From: Caitlin Cameron
To: Fraser, Jean
Date: 1/22/2014 4:50 PM
Subject: 118 Congress Street comments - PB hearing 1/28/14

From: Caitlin Cameron
To: Fraser, Jean
CC: Barhydt, Barbara
Date: 12/13/2013 11:56 AM
Subject: B1 comments revised - 118 Congress

1 NORTH ELEVATION
1/8" = 1'-0"

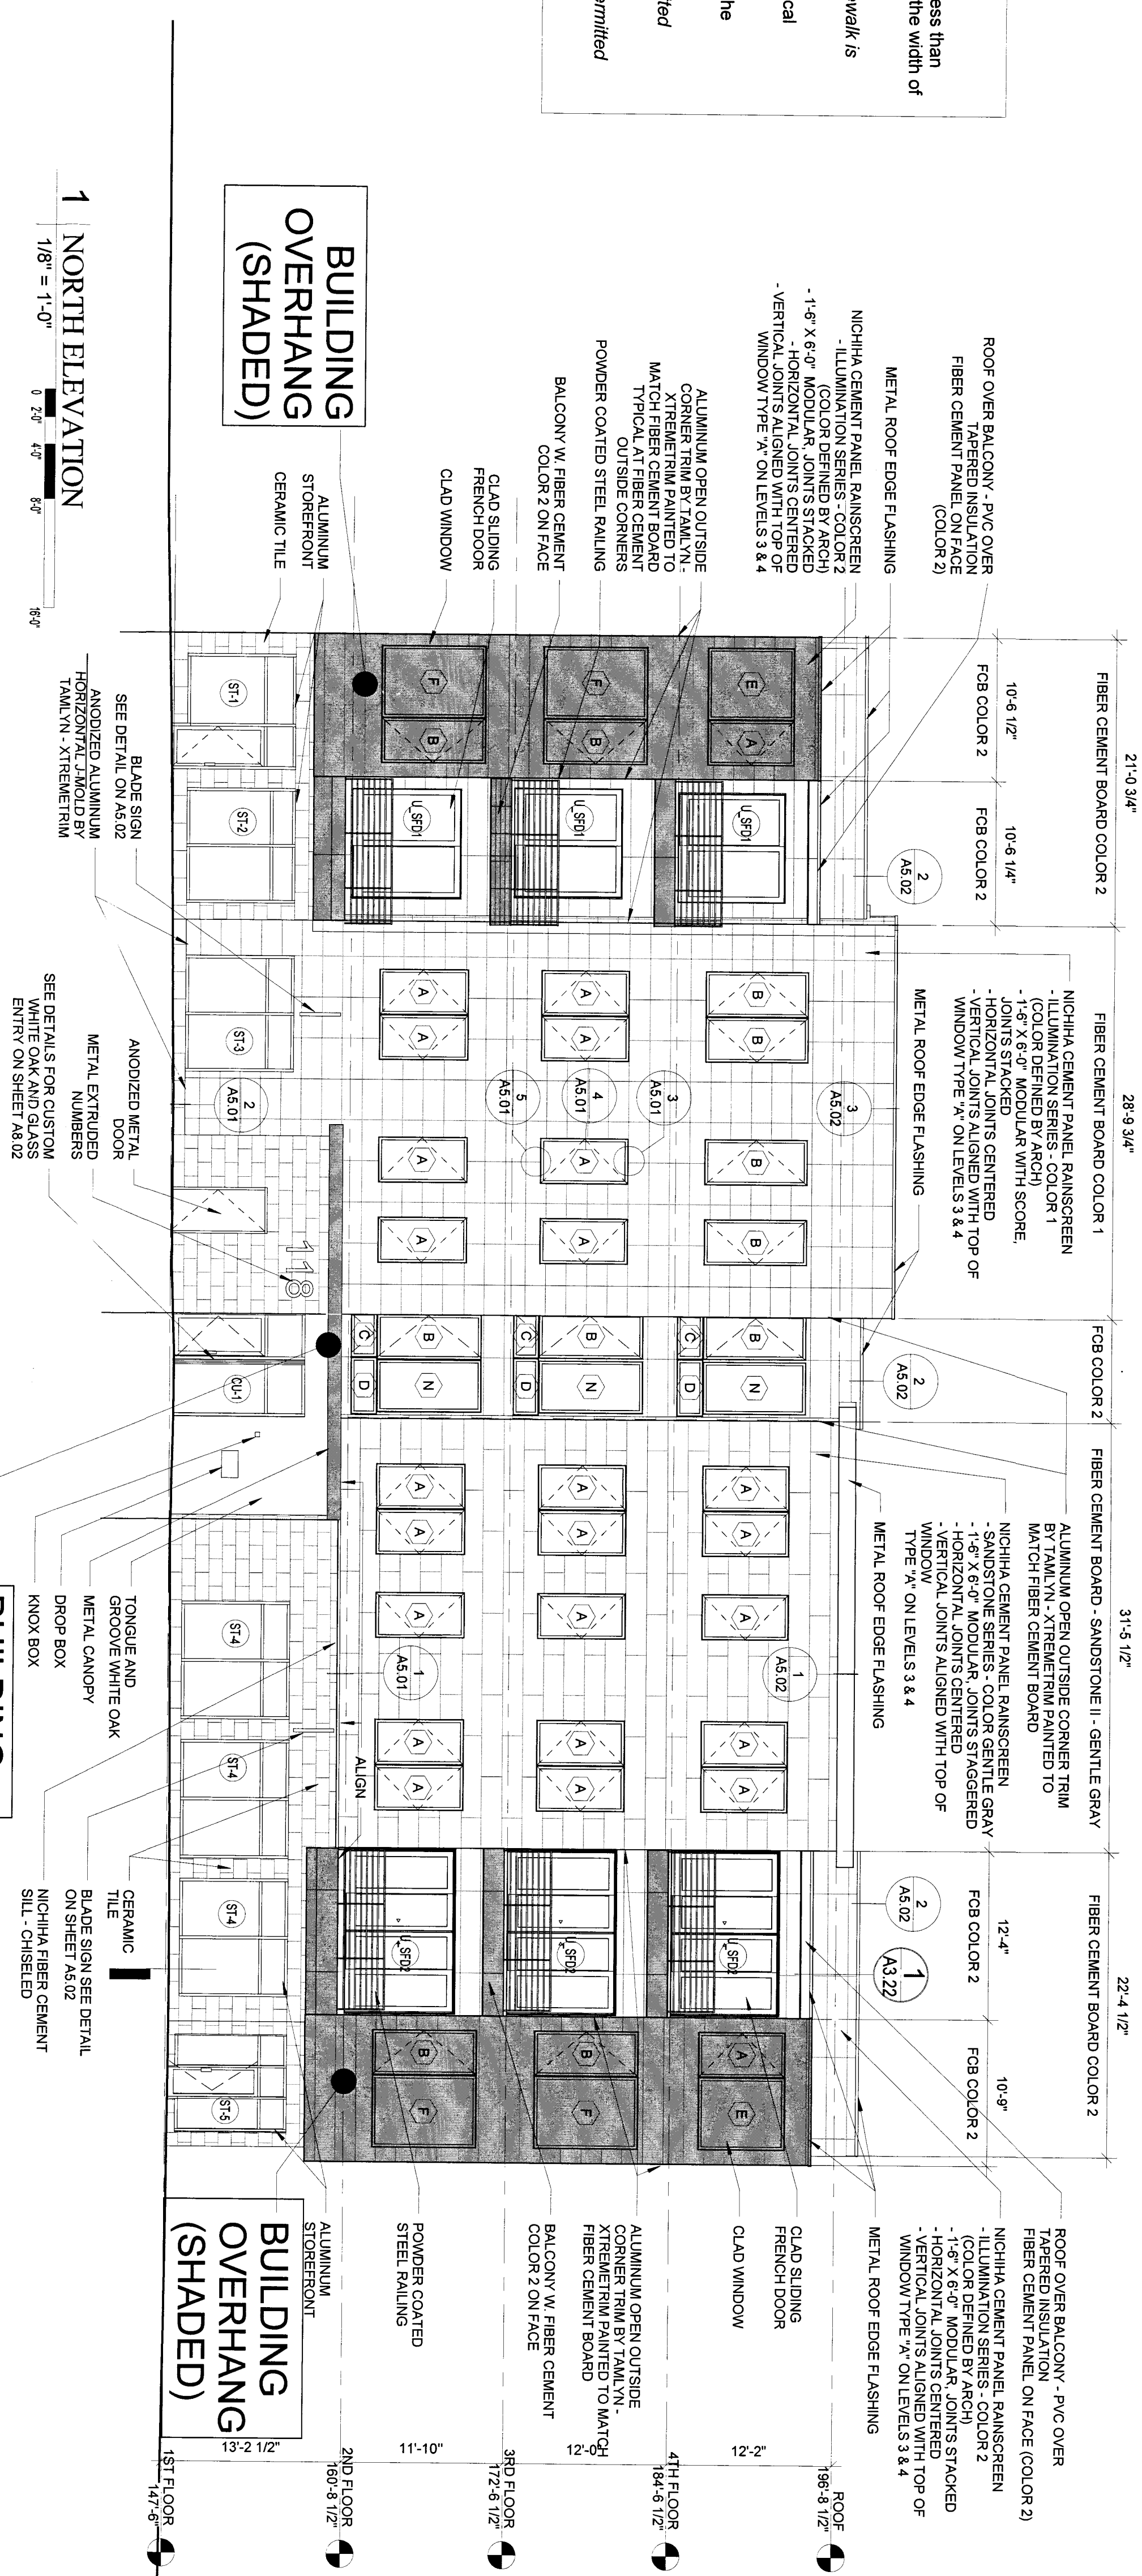
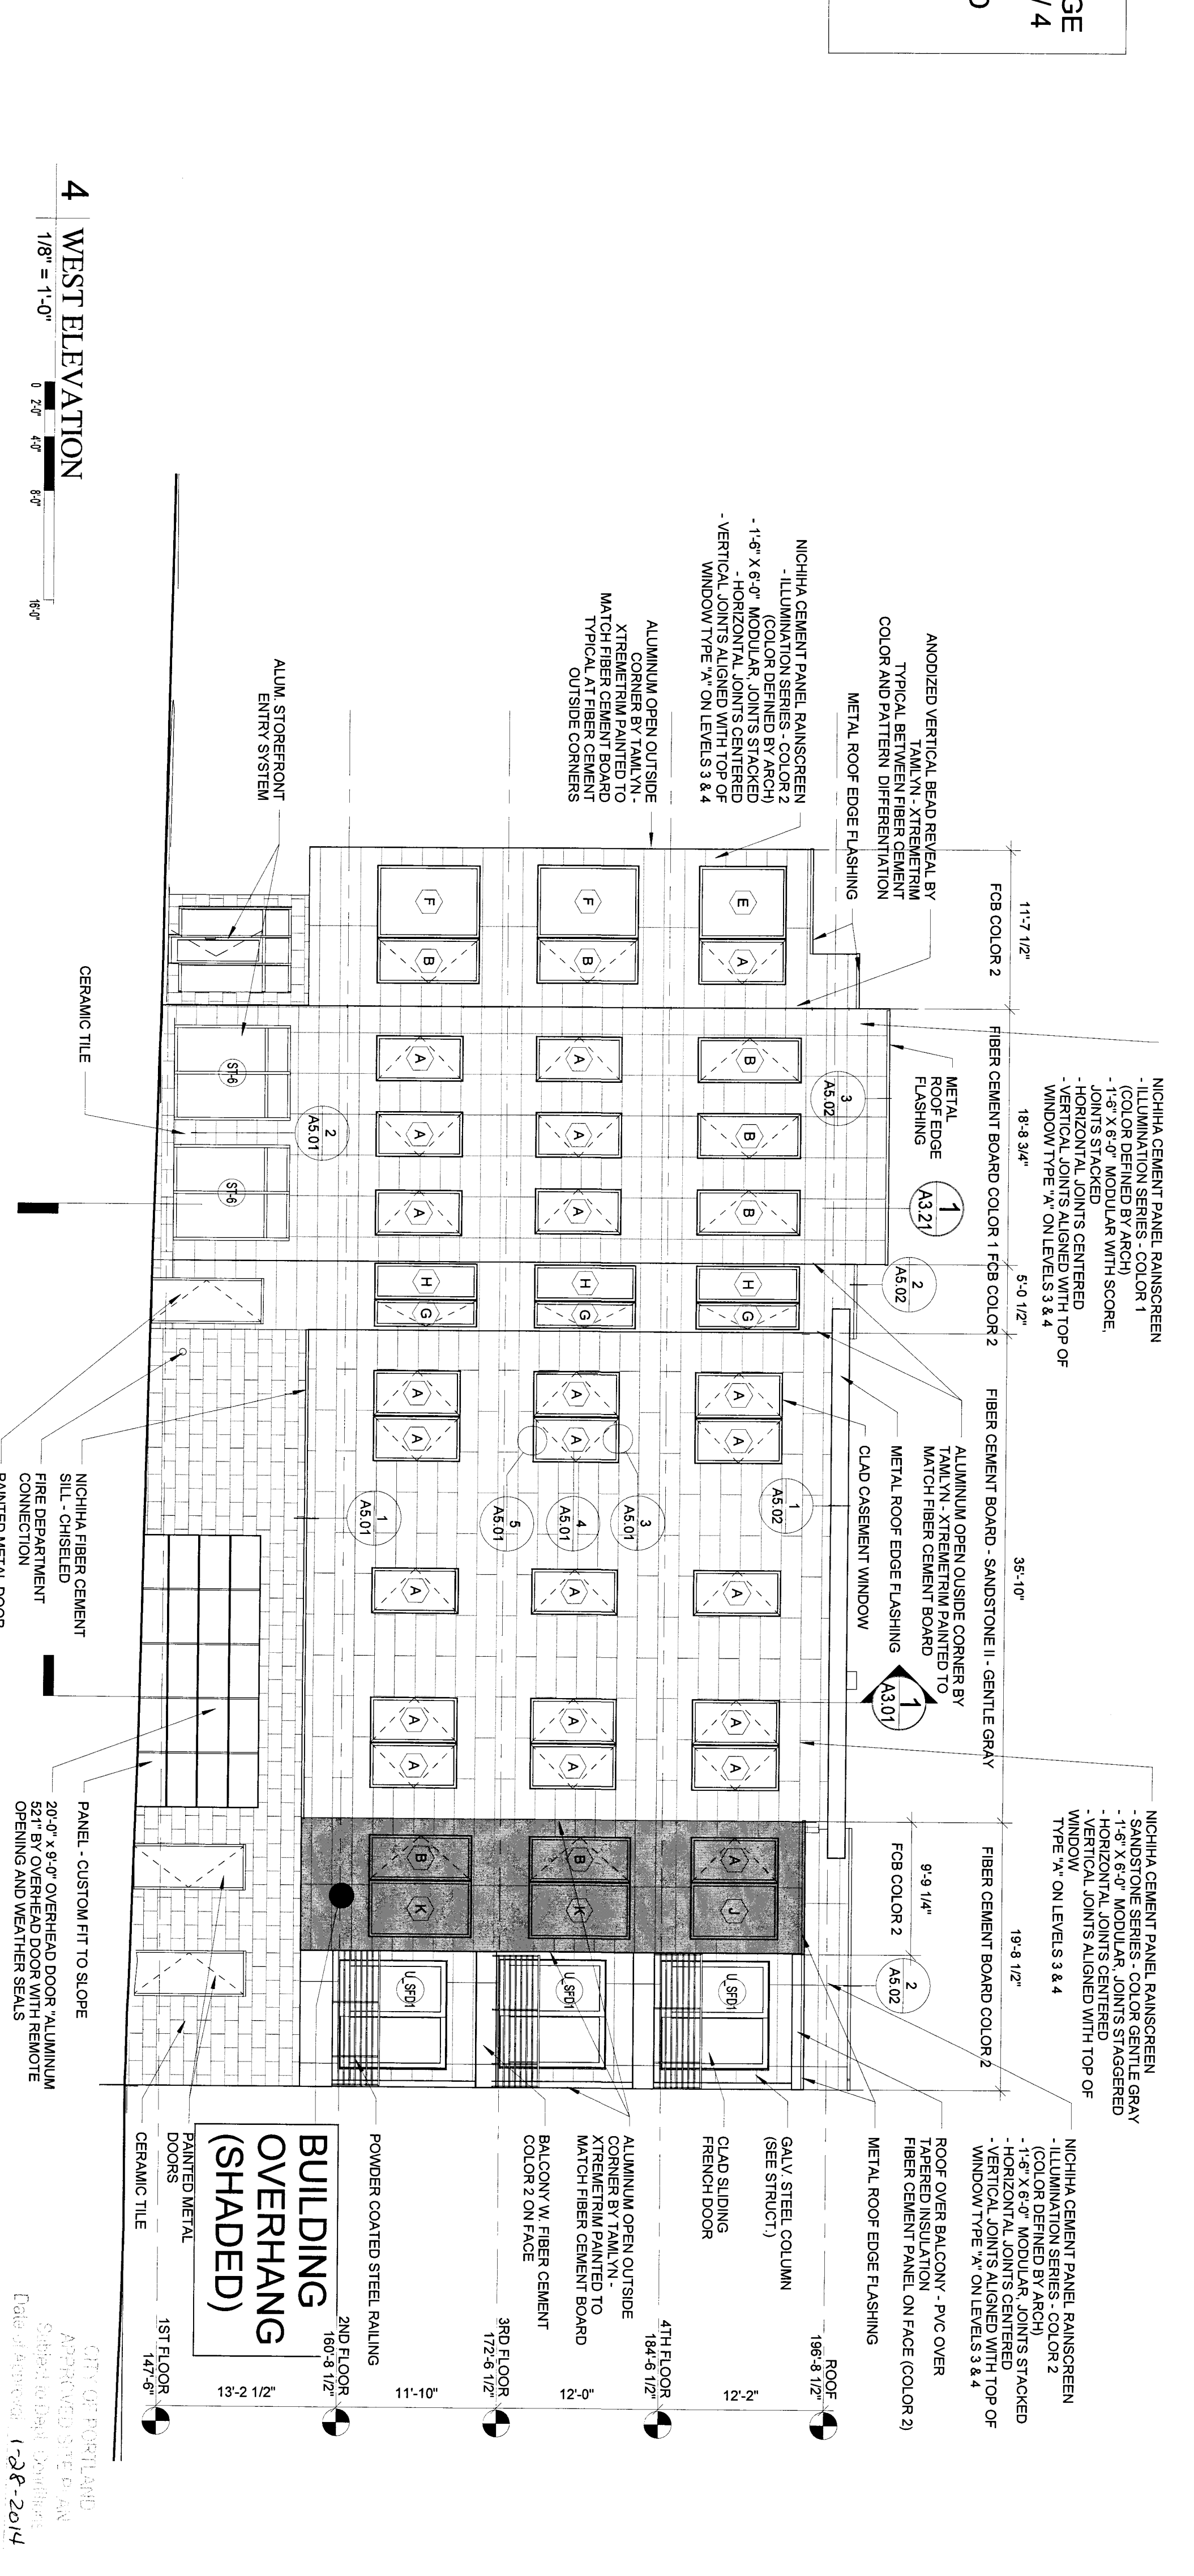
In regards to the architectural elements proposed to overhang the public right of way, unlike other exceptions where this kind of easement over the right of way was granted, this project is not limited by site constraints, existing structure, or by maintaining historical character. The articulation of the facade is a benefit to the streetscape and produces a good design that meets the design standards. If the Planning Board decides that the overhangs into the public right-of-way are not appropriate, then staff would encourage the resulting design solution maintain the current quality of design in regards to facade articulation and variation of form.

In regards to the architectural elements proposed to overhang the public right of way, unlike other exceptions where this kind of easement over the right of way was granted, this project is not limited by site constraints, existing structure, or by maintaining historical character. When weighing the impact of this aspect of the project on the public realm the following conclusions were reached. The articulation of the facade is a benefit to the streetscape and produces a good design that meets the design standards. However, the size of the lot would not preclude the articulation from occurring within the property line. In fact, the neighboring houses appear to be set back from the property line a foot or two to accommodate bay windows and/or porch steps. Stepping the retail facades back a foot or two would not negatively affect the street wall. Another possible detriment to the public includes the drip line of the overhangs onto the pedestrian path which could result in safety and comfort concerns. The protruding bays and balconies will also interfere with the growth and placement of street trees, and therefore reduce the quality and benefit of the right of way to the public. And finally, there is some concern about the affect on the public views to the Observatory. I would request renderings that look straight up and down Congress Street to understand how far into the view corridor the balconies project and how it affects view corridors.
